Applicant Response to GLA (Green Infrastructure)

Planning Application Reference 2382/APP/2023/2906

Broadwater Lake, Moorhall Road, Harefield, UB9 6PE

APPENDIX 3: TREE IMPACT AND RETENTION PLAN

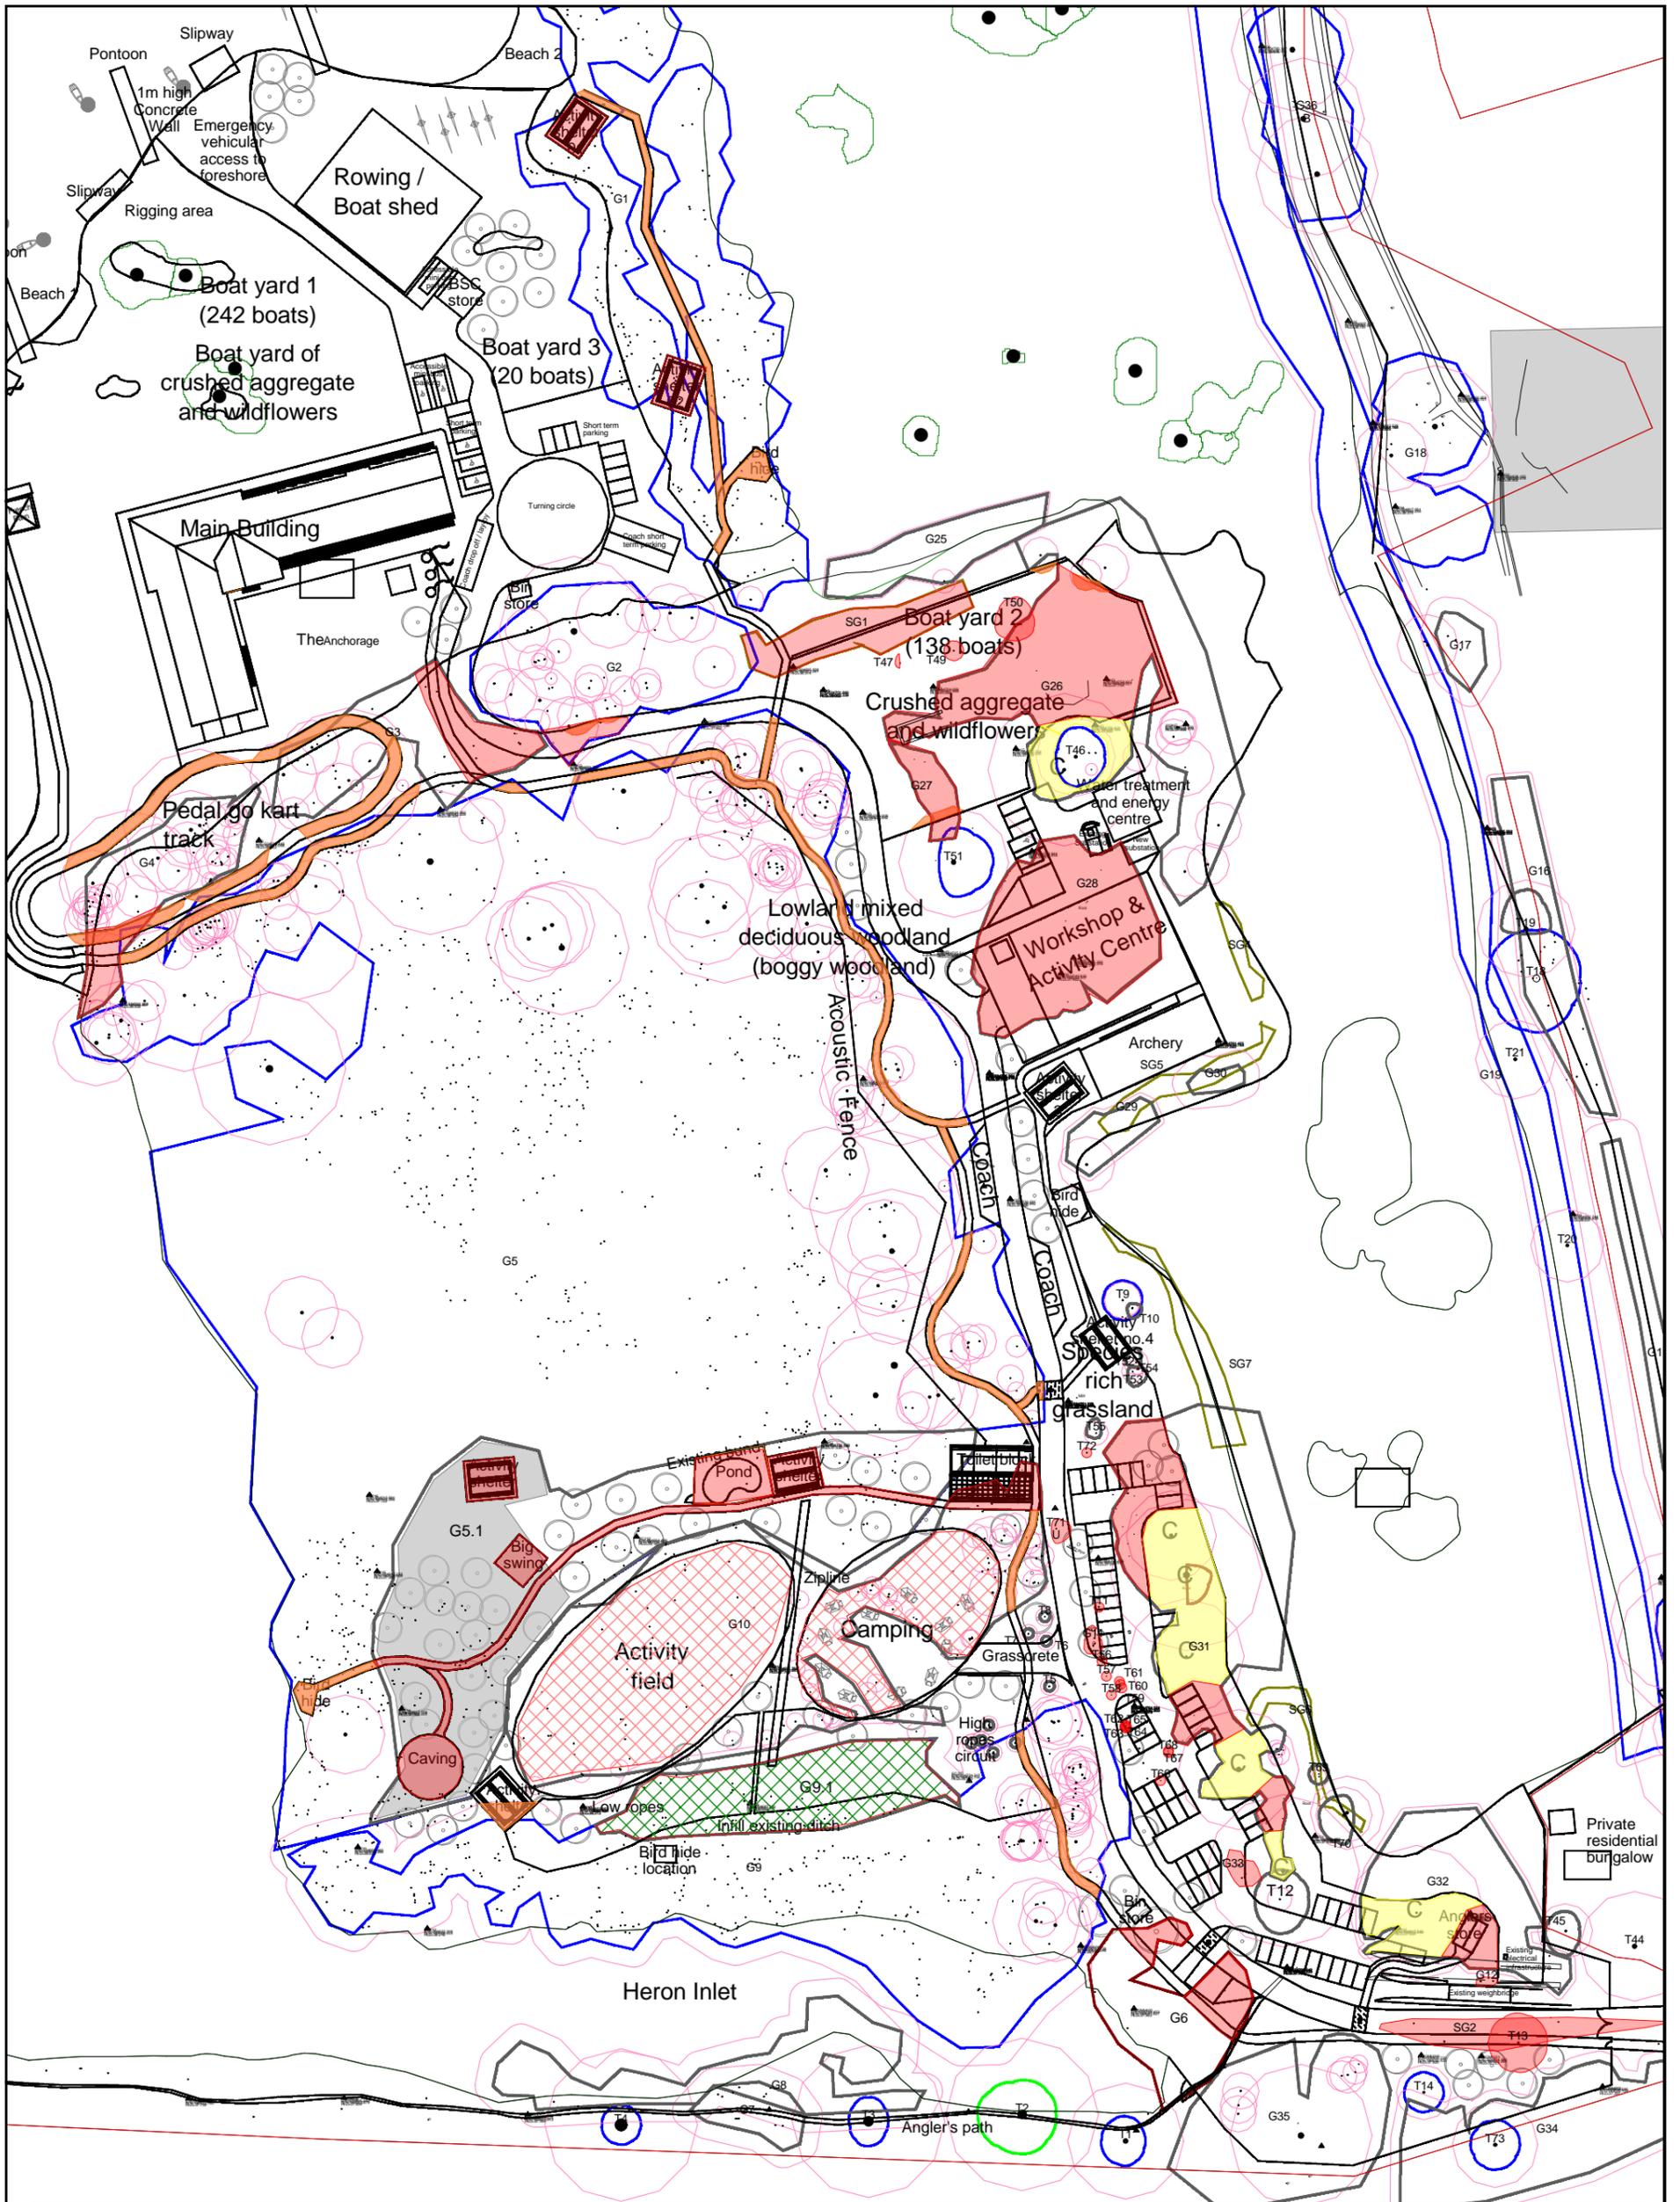
<p>There are a number of existing trees on site. The arboricultural report states that 8 Category B and 8 Category C trees are to be removed. Wherever possible, trees of value should be retained.</p> <p>The application should provide an assessment of the value of the trees to be lost using the appropriate</p>	<p>With regard to the use of ‘i-tree’ or ‘CAVAT’, these systems are designed for use with individual trees rather than components of a woodland. There is only one accepted valuation system for woodland, the Helliwell system. The Arboricultural Association state the following about the Helliwell system:</p>

valuation system and set out how this has been accounted for through replacement tree planting within a reasonable timescale, such as 15-20 years to allow proposed trees to establish and mature. Tree value can be derived from 'i-tree' or 'CAVAT', or another appropriate valuation system, in accordance with Policy G7 of the London Plan. Without this valuation comparison, compliance with Policy G7 cannot be determined. The applicant should clarify the number of trees proposed.

This system uses 6 criteria to produce scores which are then multiplied together to form a total score (using the Helliwell formula). The table below shows the scores for each criterion in this instance:

Size of Woodland	1
Position in Landscape	2
Viewing Population	2
Presence of other trees and woodland	0.5
Composition and structure of woodland	2
Compatibility in the landscape	3
Total	12

The Arboricultural Association lists the unit vale for woodlands as £215.94. Hence the part of the woodland to be removed is valued at £2591.28.

Given that the replacement planting would be subject to the same scoring other than size, this is the only variable to consider. The table below scores the replacement planting, with a total value of £5182.56.

Size of Woodland	2
	Position in Landscape	2
	Viewing Population	2
	Presence of other trees and woodland	0.5
	Composition and structure of woodland	2
	Compatibility in the landscape	3
	Total	24

Whilst the figures are substantially less than CAVAT, in particular, that is not the relevant point in this instance: the relative values are the important factor and these would be the same regardless of the valuation system due to the sheer number of replacement plantings. To conclude, the removals are more than adequately mitigated in the replacement planting.
